## PRELIMINARY BCA ASSESSMENT REPORT

<b>To:</b>	Goodman		
<b>Attention:</b>	Richard Seddon	<b>Date:</b>	11/9/2008
<b>From:</b>	Tony Heaslip	<b>Sent by:</b>	Email
<b>Project:</b>	ARCBS – 17 O’Riordan St Green Square	<b>Project No:</b>	80313
<b>Copies:</b>	Goodman – Adrian Tesoriero	<b>Pages:</b>	11

The proposed development involves the construction of a processing facility for the Australian Red Cross Blood Service (ARCBS) containing a processing plant, laboratories, office administration areas, warehouse and basement car parking for 97 vehicles.

DRAWING NO
DA-D-003
DATE
06.08.08
ISSUE
A

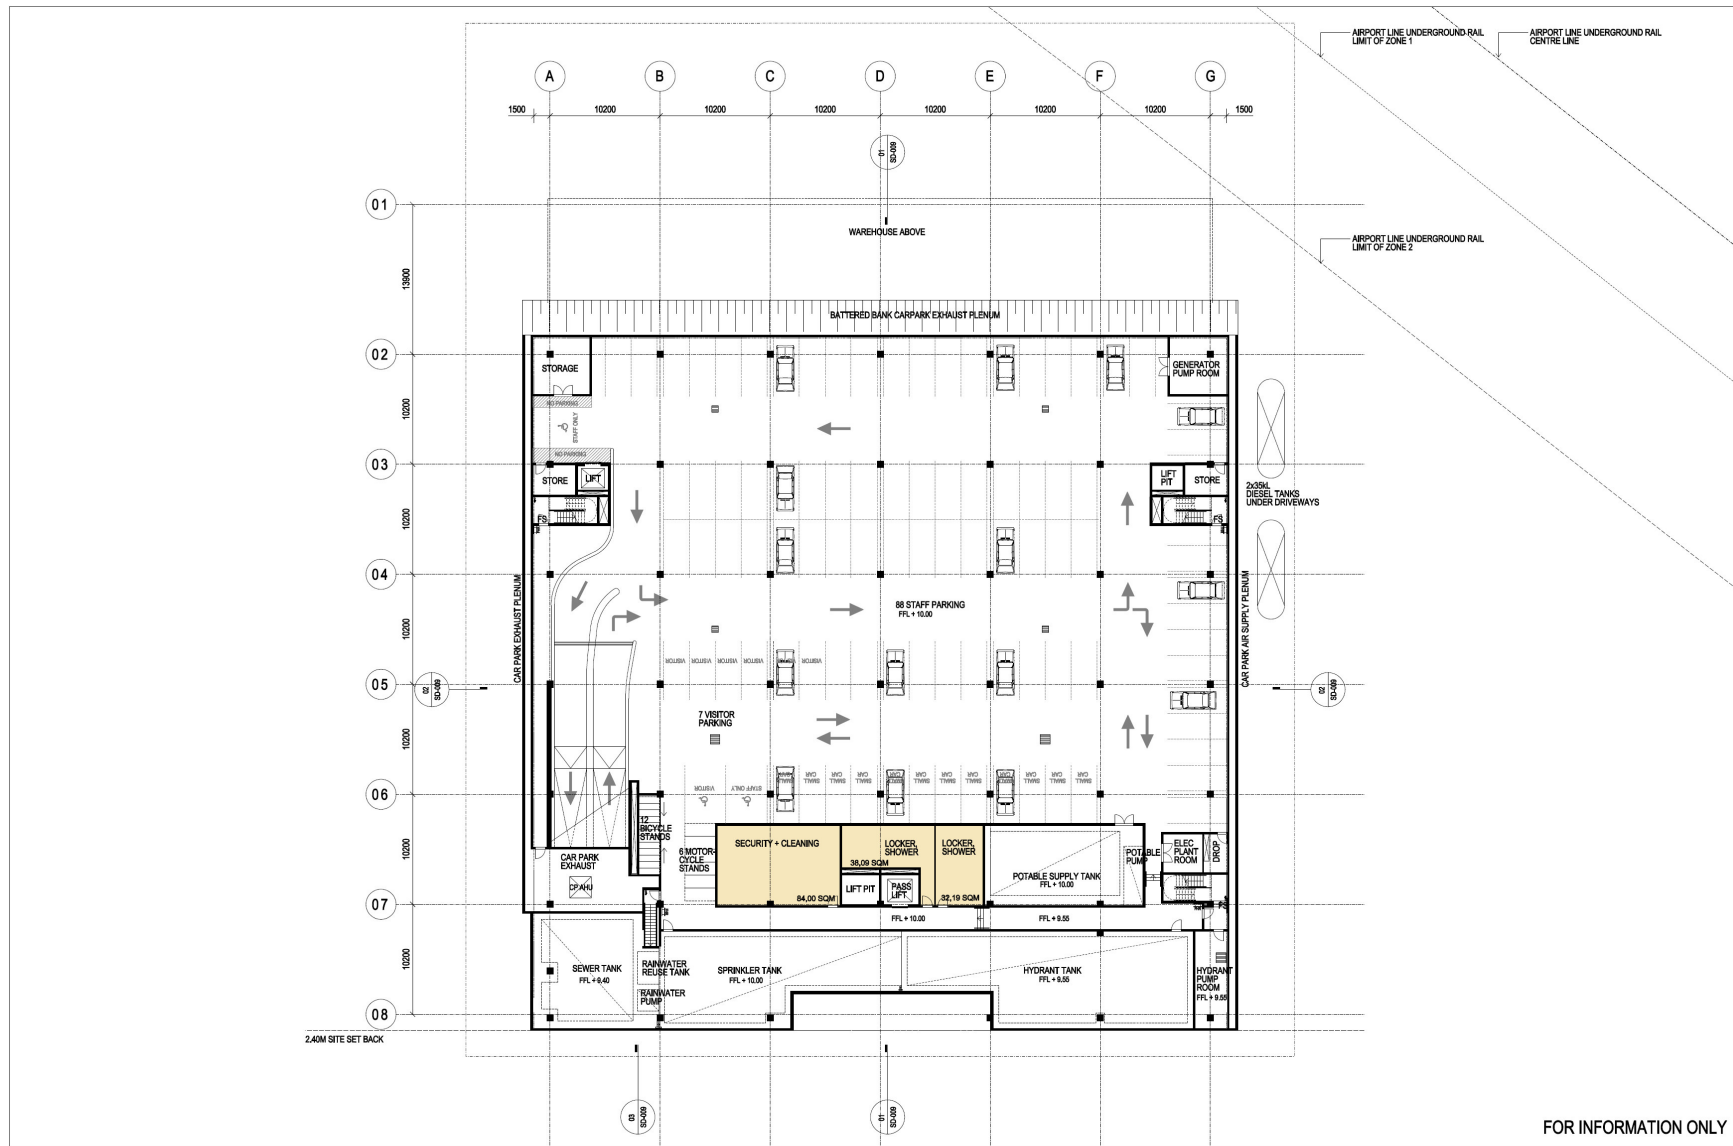
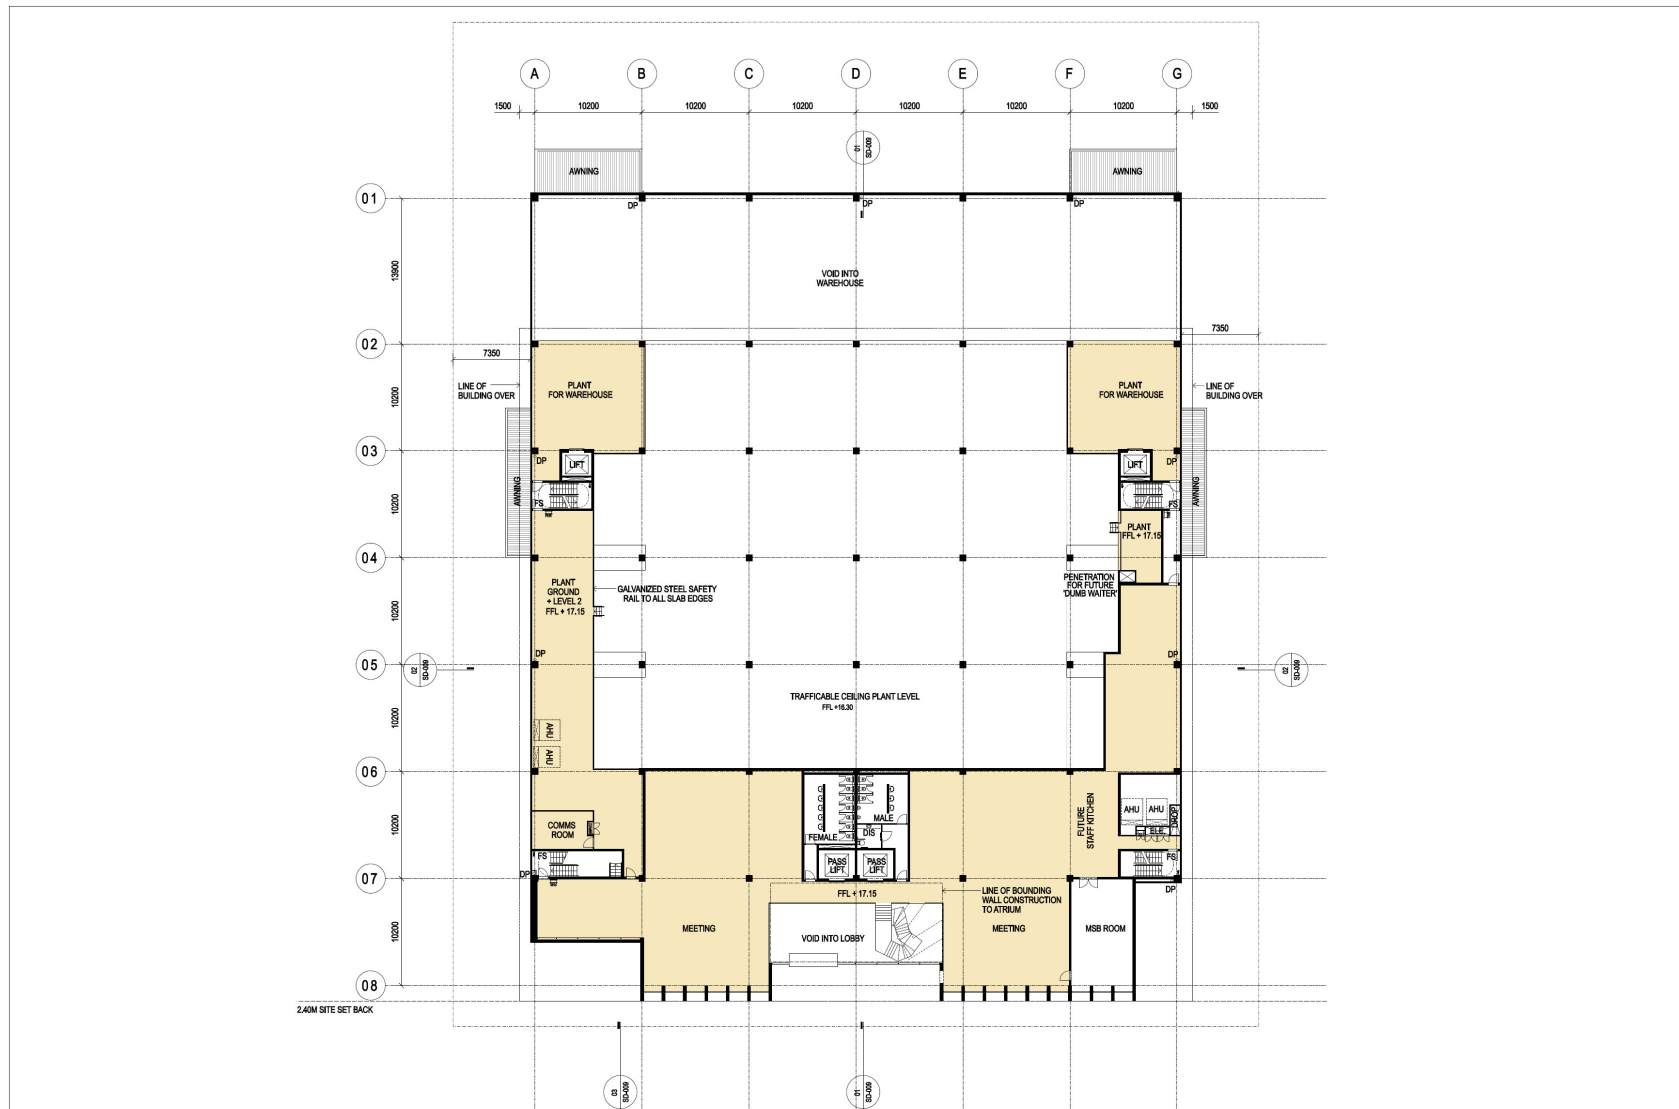
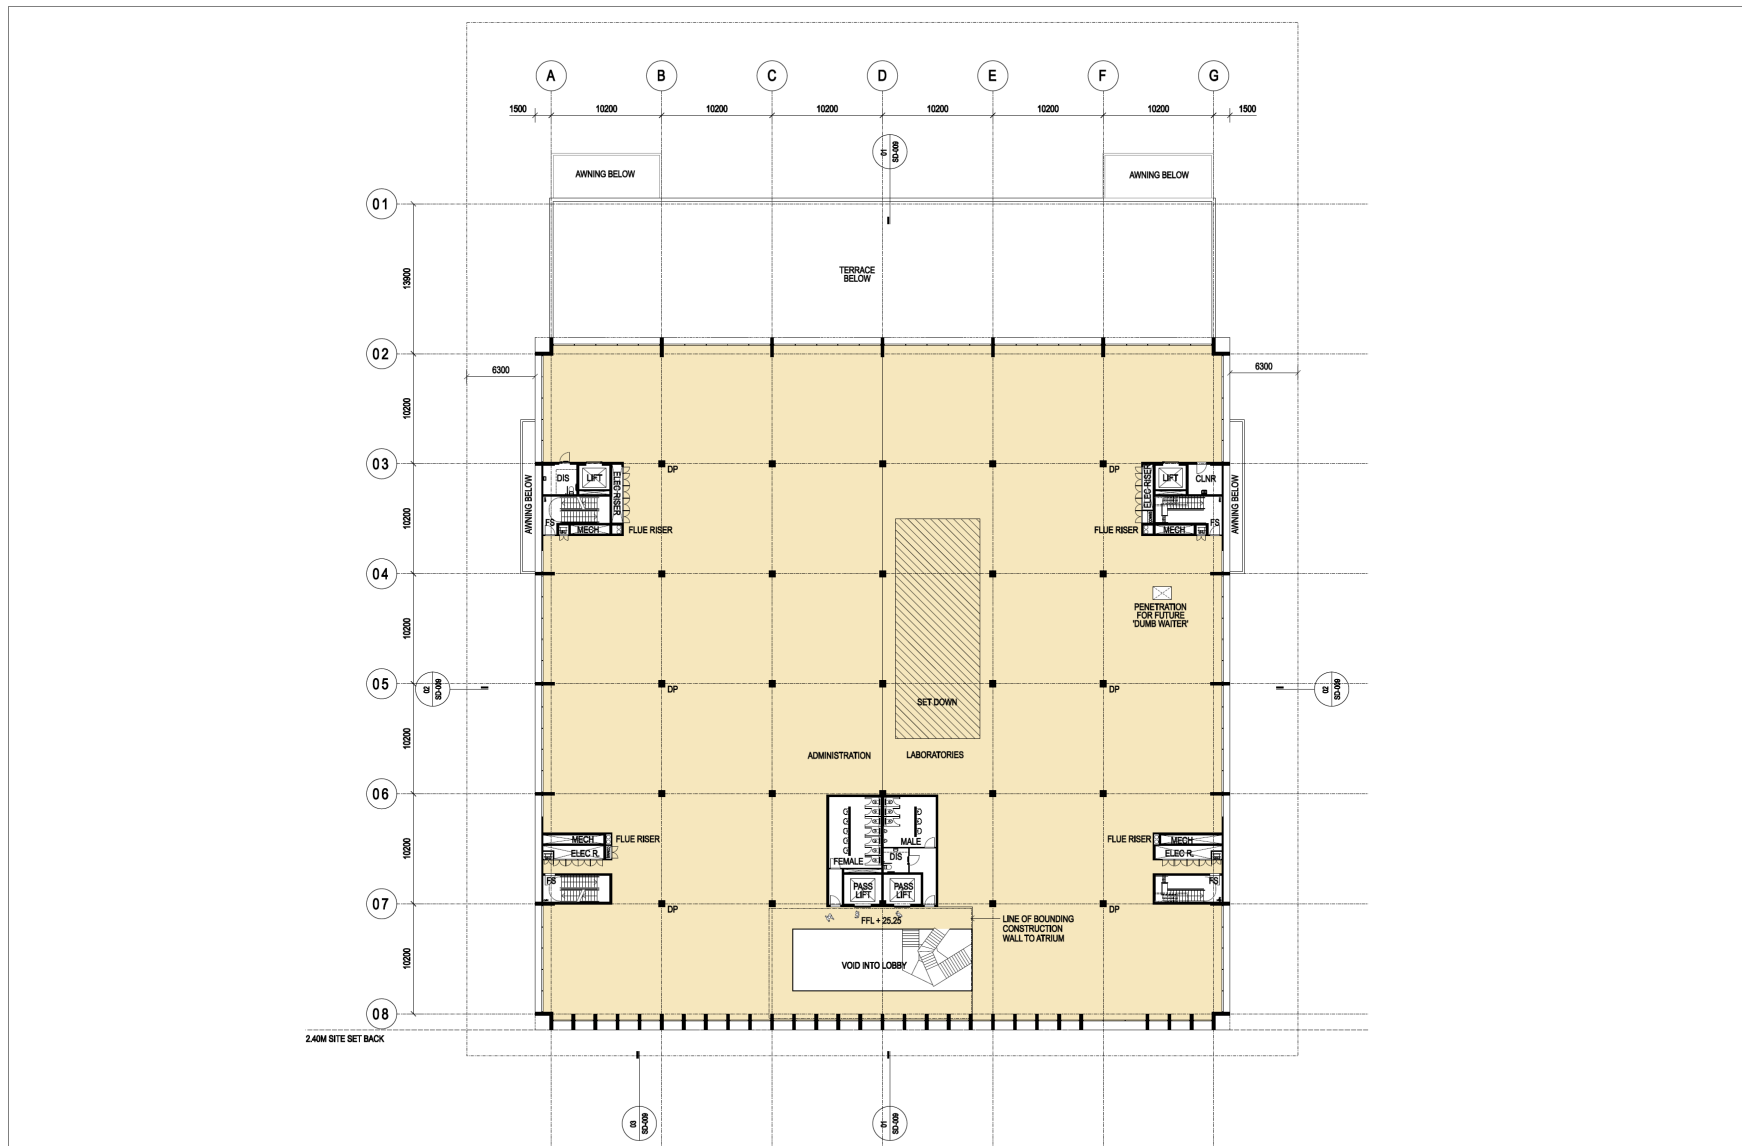
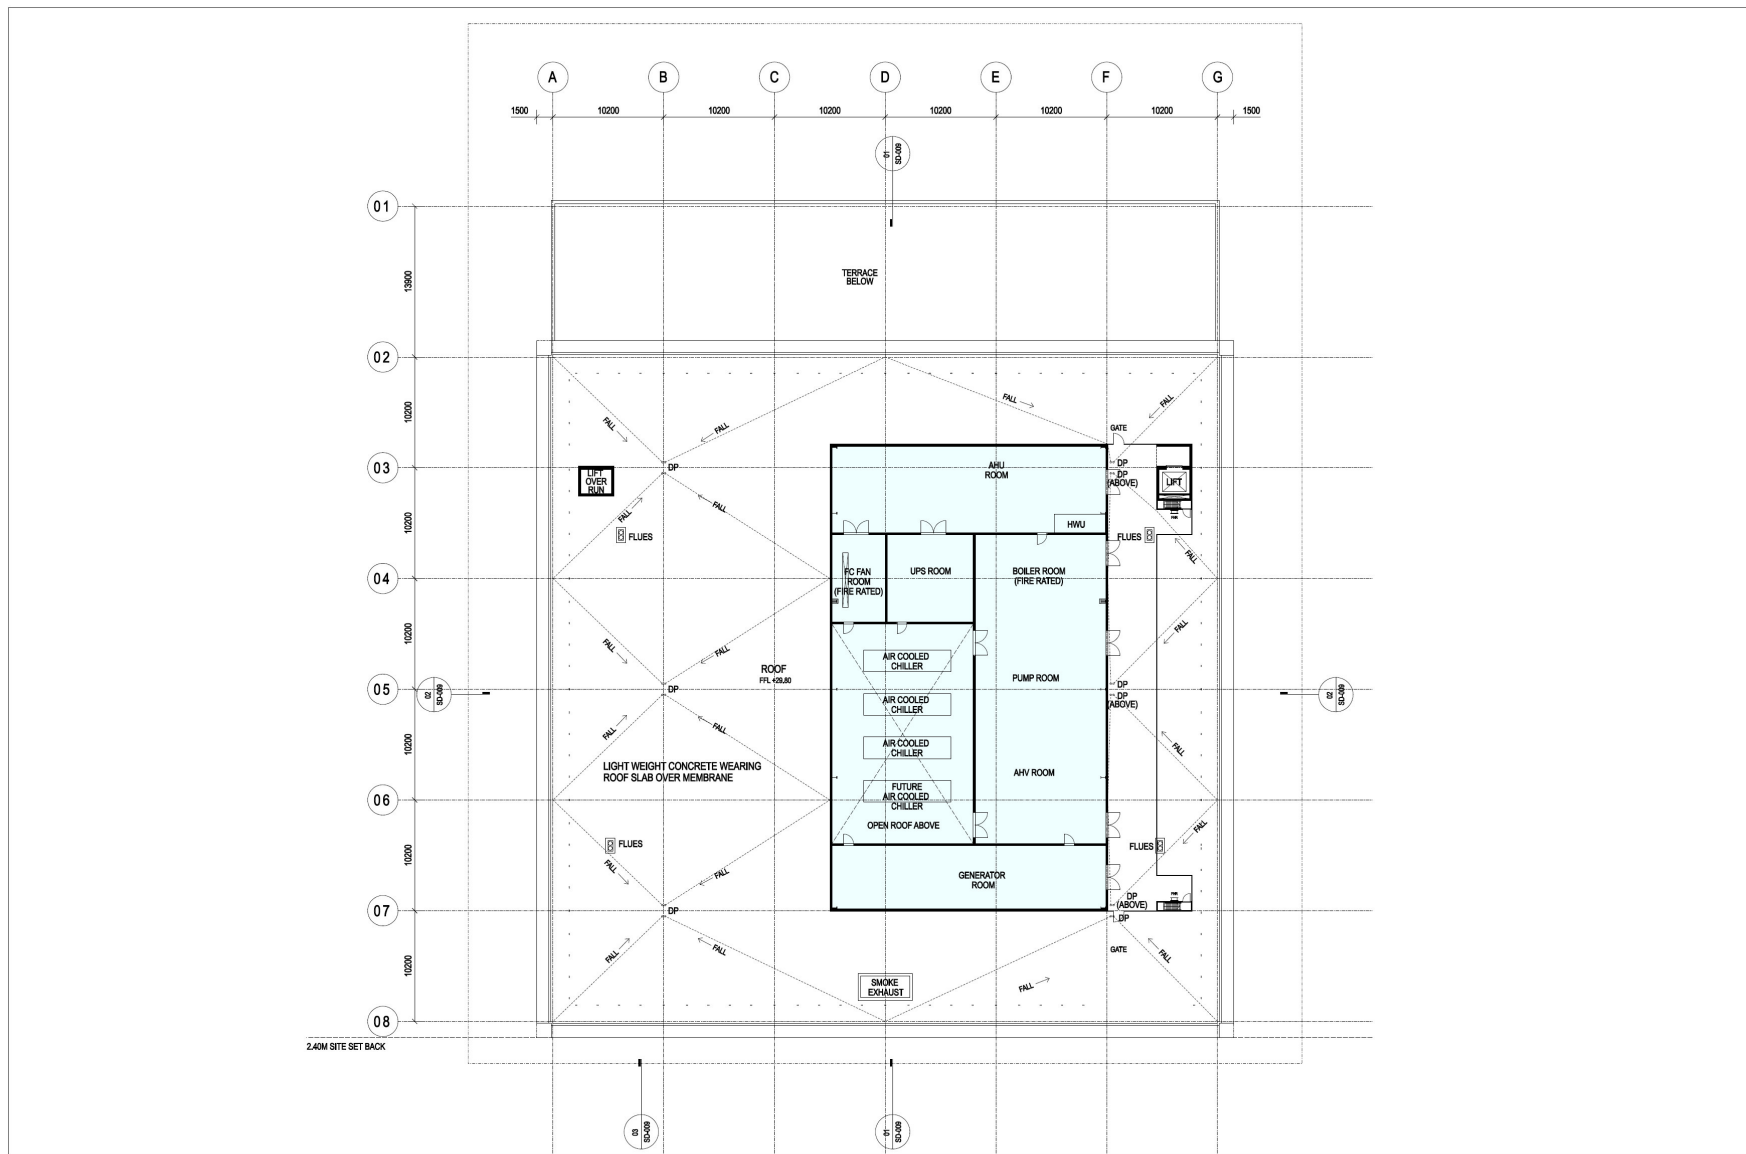
- Level 3 (incl. fitout):  
Distance to one of two alternative exits exceeds the prescribed maximum of 40m (51m proposed).
- Level 2 (incl. fitout):  
Distance to a point of choice to alternative exits exceeds the prescribed maximum of 20m (maximum 28m proposed from external Terrace).  
Distance to one of two alternative exits exceeds the prescribed maximum of 40m (maximum 50m proposed).
- Level 1 (incl. fitout):  
Distance to one of two alternative exits exceeds the prescribed maximum of 40m (maximum 45m proposed).
- Ground Floor (incl. fitout):  
Distance to one of two alternative exits exceeds the prescribed maximum of 40m (maximum 50m proposed).

- Level 3 (incl. fitout): Distance between alternative exits exceeds the prescribed maximum of 60m (maximum 76m proposed)
- Level 2 (incl. fitout): Distance between alternative exits exceeds the prescribed maximum of 60m (maximum 77m proposed)
- Level 1 (incl. fitout): Distance between alternative exits exceeds the prescribed maximum of 60m (maximum 66m proposed)
- Ground Floor (incl. fitout): Distance between alternative exits exceeds the prescribed maximum of 60m (maximum 88m proposed).
- Basement carpark: Distance between alternative exits exceeds the prescribed maximum of 60m (maximum 62m proposed).

The above exit travel distances non-compliance will be required to be addressed by an Alternative Solution which addresses BCA Performance Requirements DP4 and EP2.2.

The above non-compliances will be addressed by an Alternative Solution to address Performance Requirements DP4 and EP2.2.
